Submissions Report

Major Project 05-0038

Proposed Subdivision of Lot 542 DP113791, Lot 156
DP753202 and Lot 53 DP836998

Date: 13 April 2022

Figure 4 - Proposed lot layout (with staging plan)

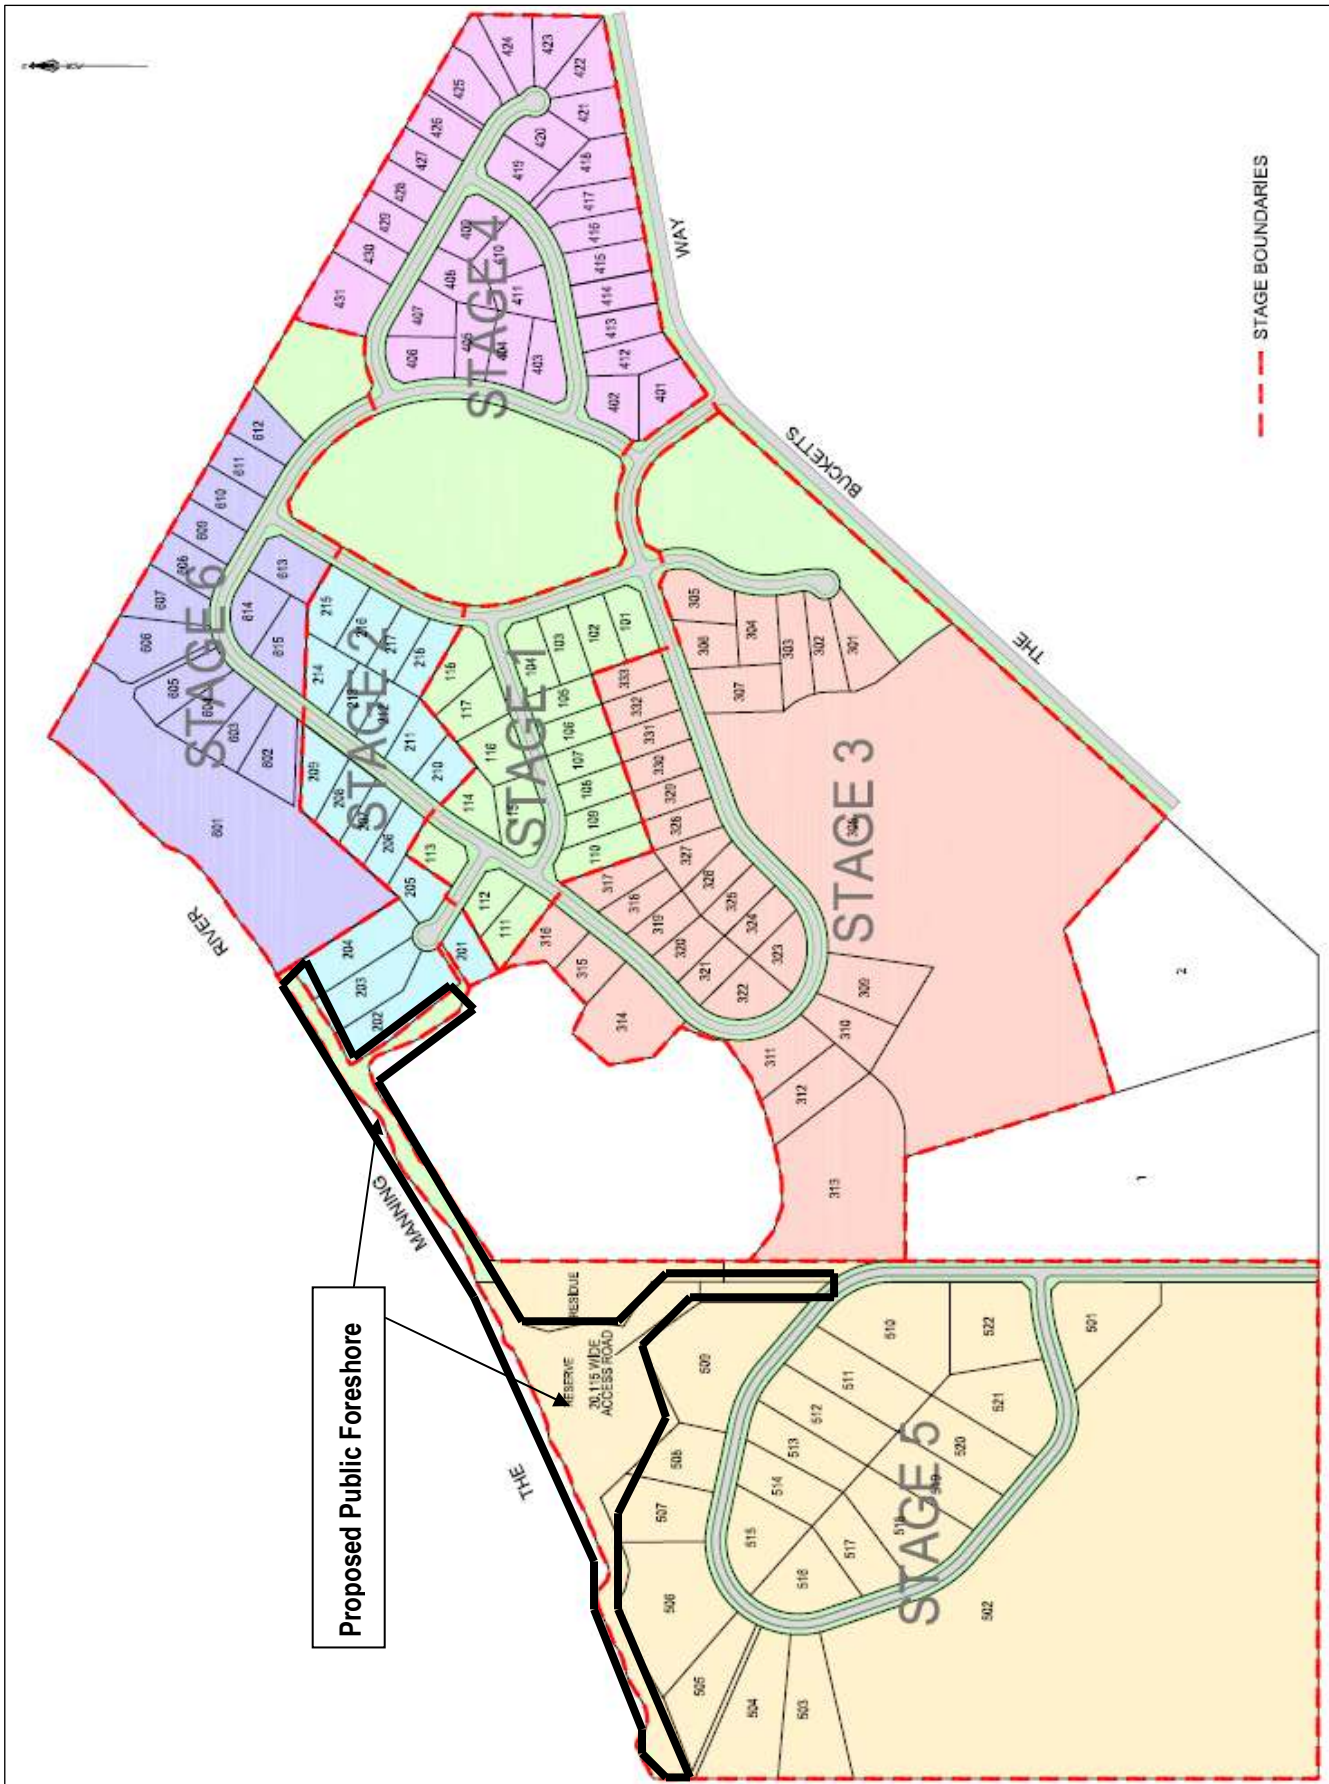
- The amended plans provide additional lots over 916 / 917 and 924. In our opinion, there is inadequate justification provided for these lots. The proposed Lot 917 appears to be divided into two separate areas. This appears impractical. The northern part of proposed Lot 917 should be deleted and incorporated into the dedicated public foreshore reserve.*

- *Proposed Lot 924 is not considered a suitable lot given its numerous constraints.*

Requirements for Asset Protection Zones and following requests from Midcoast Council, there has been a reduction in the number of lots in Stage 2 of the proposed subdivision as follows:

- Deletion of former Lots 923 and 924;
- Consolidation of former Lots 916 and 917 into one larger lot; and
- Incorporation of part of the former Lot 917 into the future Public Reserve to be dedicated to Council.

Figure 5 - Vegetation Retention, Clearing and Rehabilitation Plan

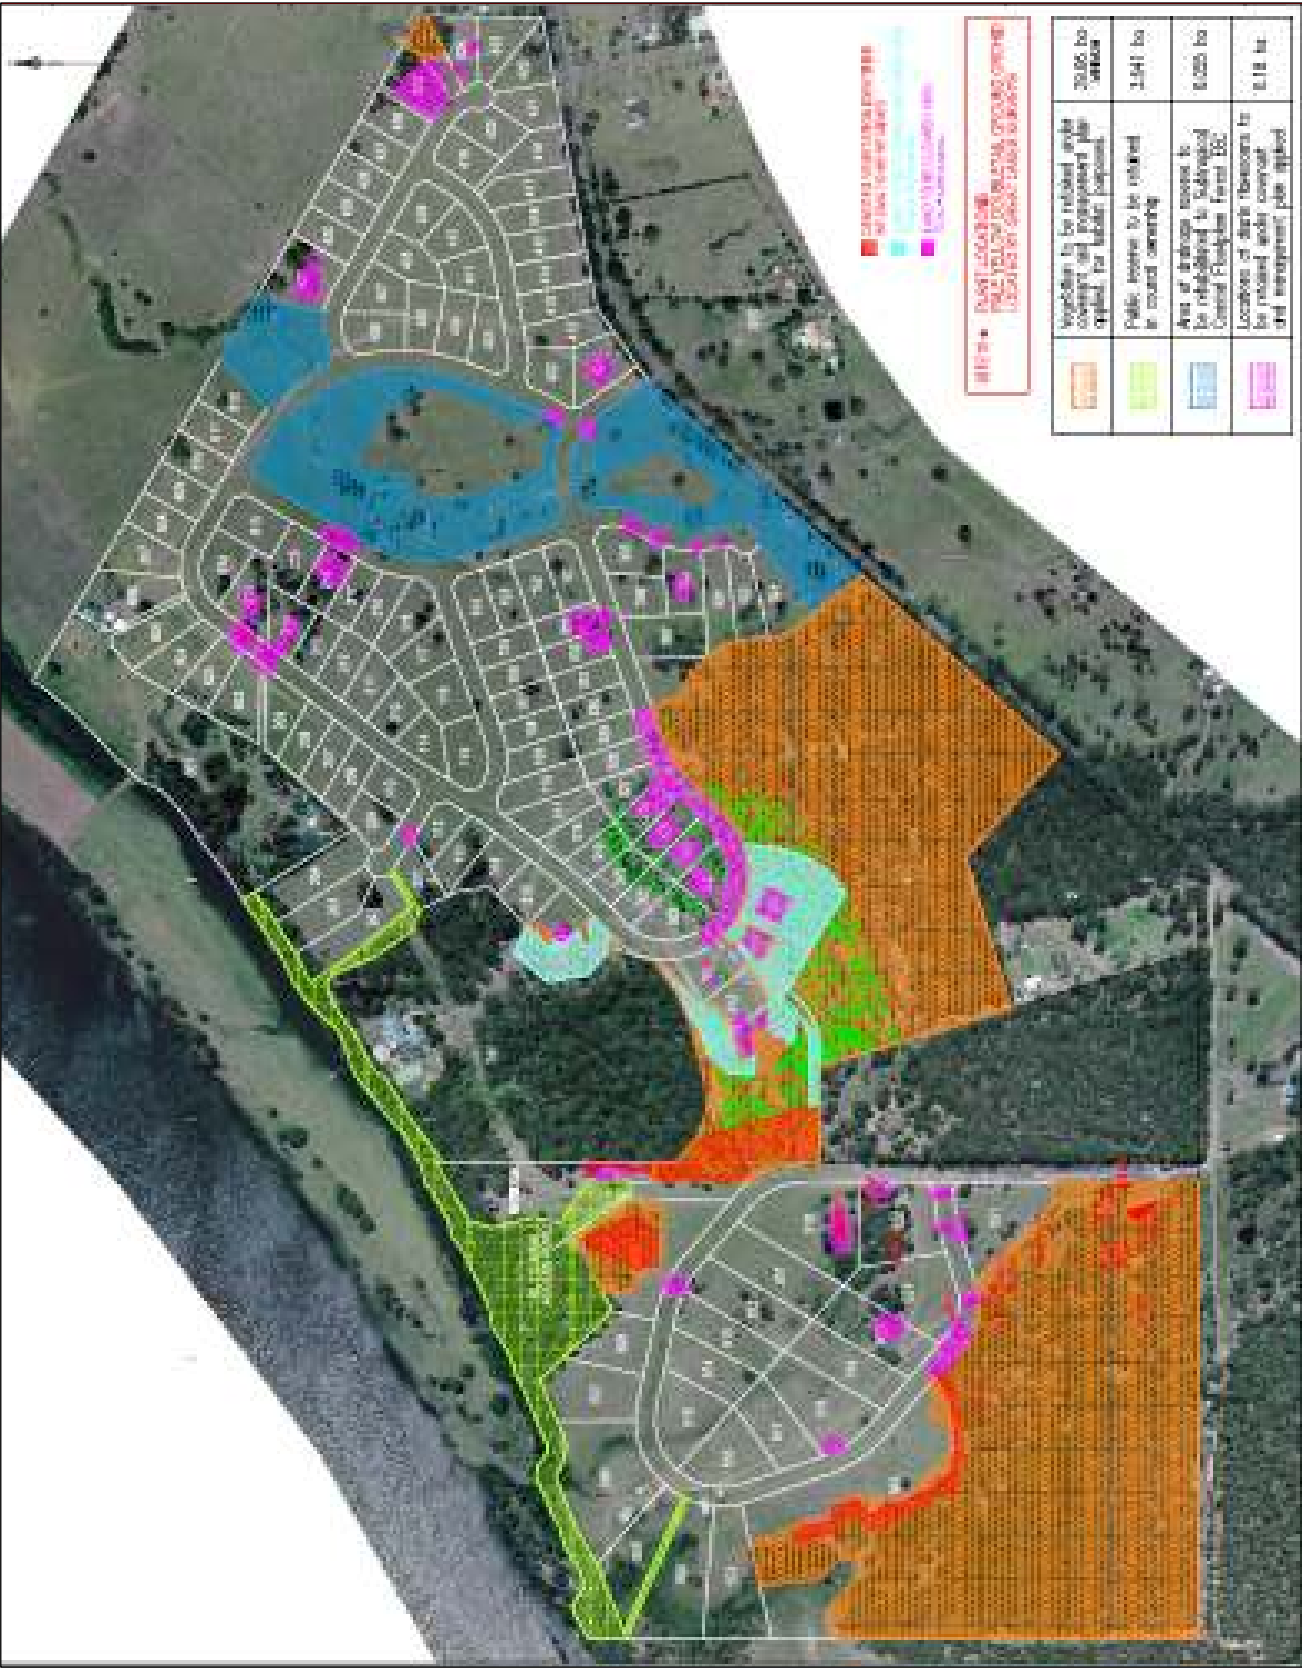
- *We raise the following issues associated with **Figure 8: Vegetation removal / retention plan**:*

- *Proposed lot 924 is a new lot and contains vegetation previously approved and still proposed to be retained. Creation of this Lot is sub-optimal and would result in a loss of significant vegetation that was originally proposed for retention / private conservation,*

- *An APZ is proposed over the road reserve to the dedicated public foreshore reserve. This is inappropriate and can be avoided by a building envelope and APZ on the proposed lot,*

- *The road access to the western side of the development from Urray Rd has shifted slightly to the east and now includes a significant area of vegetation (an IPA APZ is also proposed in this area – see APZ map). Is this a mapping error or is this vegetation now proposed to be removed? If so, this vegetation has not been accounted for in the clearing calculations on page 23 and could result in a greater impact than the approved subdivision layout and thus trigger the requirement to prepare a BDAR.*

We have been in ongoing consultation with RFS and Council in relation to the extent of Asset Protection zones and consolidation of some lots to reduce ecological impacts. This consultation has resulted in minor changes to the lot layout.

Amended plans of the proposed lot layout which indicates the extent of vegetation clearing and vegetation retention are included at Appendix C.

The vegetation clearing for the proposed subdivision is now:

70% - 0.96 ha

85% - 1.85 ha

100% - 0.20 ha

Total – 3.01ha

This compares to 4.36ha proposed to be cleared for the approved subdivision.

Figure 13 - Location of *Diuris flavescens*

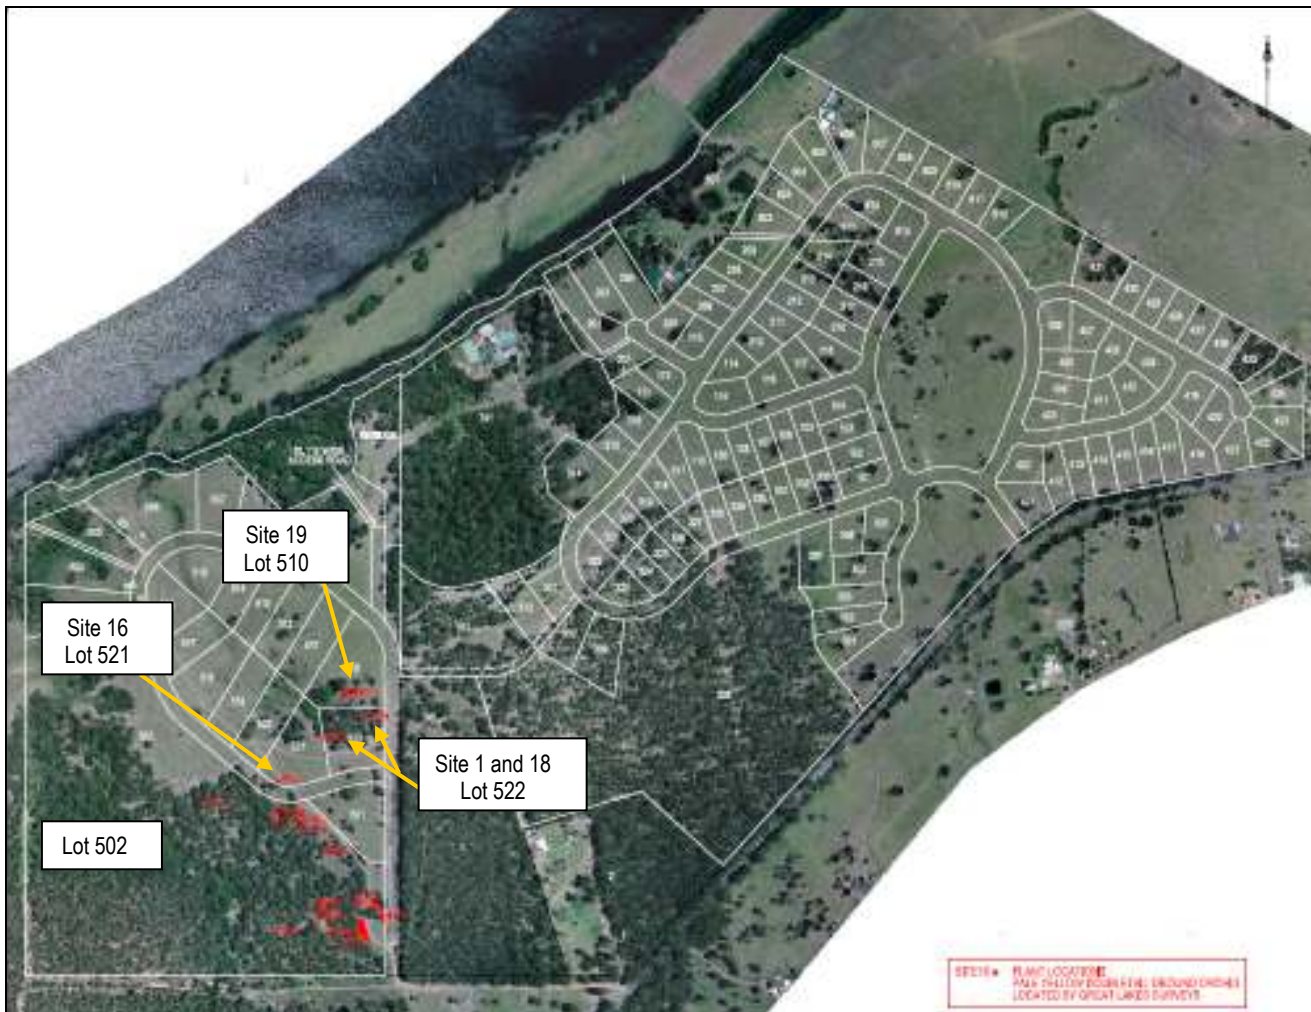
- The original Ecological Assessment identified that an updated survey of the critically endangered Pale Yellow Doubletail was required to be undertaken in September 2020 during the flowering season. There is no evidence that this survey has been undertaken. Council staff are indeed aware of several individuals of this critically endangered species being present in the road reserve over which the access road to Stage 2 is proposed to be constructed. This survey is **critical** to informing the finalisation of the Stage 2 subdivision layout boundaries, building envelopes and conservation areas. We would respectfully ask that additional surveys are required and that additional consultations with both NSW and Australian Government*

- environmental agencies prior to determining any modification application for Stage 2. This requires significant re-evaluation because the proposed Stage 2 development could, in our opinion, significantly endanger *Diurus flavescens*, and needs further assessment (under the EPBC Act 1999 for instance). Additional surveys and focussed consultations would be able to define the most appropriate subdivision arrangement for Lot 156 and should frame the dedication of all conservation important land to a public authority rather than rely on private conservation instruments over several lots. This may have implications for proposed Lots 902, 903, 904, 924 and 925, in particular.*

The revised layout, as a result of required changes to lots, has resulted in LESS potential impact on the endangered flora species *Diuris flavescens*.

It should also be noted that Condition B4 (6) of the Project Approval requires the preparation of an Orchid Habitat Management Plan (OHMP) for the Stage 2 lands and is proposed to be retained in the modified consent. The preparation of this plan will require further survey for the species at that time.

On this basis it is therefore submitted that no further survey is required for *Diuris flavescens* for this proposed modification and the Condition B4 (6) is adequate to ensure the protection and conservation of this species in the future.
